COUNTY OF HARNETT LAND USE APPLICATION
Central Permitting 108 E. Front Street, Lillington, NC 27546 Phone: (910) 893-7525 Fax: (910) 893-2793 www.harnett.org

Regarding: Hunters Point, Lots 16+17. (4 pages)

HUNTERS POINT

PROPOSED SEPTIC

HUNTERS POINT
LOTS 16 & 17
PROPOSED SEPTIC

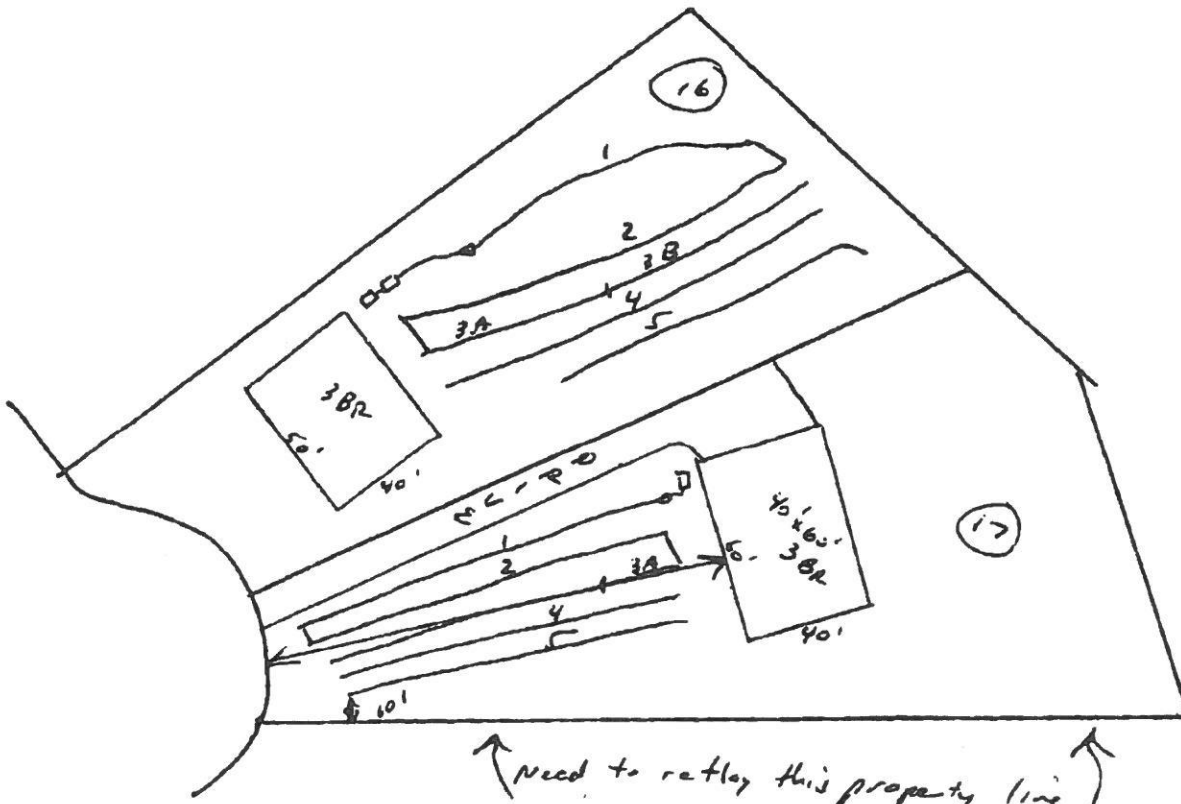
- ① LOT 16 SHOULD BE APPROVED AS YOU PREVIOUSLY SUBMITTED
- ② LOT 17 NEEDS TO BE REVISED WITH A 142' HOUSE SETBACK. YOU WILL ALSO NEED TO REFLAT LOWER PROPERTY LINE (AS SHOWN) TO VERIFY LOCATION. IT MAY NEED TO BE SLIGHTLY ADJUSTED TO MAINTAIN 10 FT. PLEASE SUBMIT NEW PLOT TO HARN CO.
- ③ I HAVE MET OLIVER (HARNET CO) ON SITE AND RECEIVED APPROVAL FOR THESE DESIGNS.

Need to reflag this property line
+ adjust into common area
if necessary

⊗ 142' HOUSE SETBACK ON
LOT 17
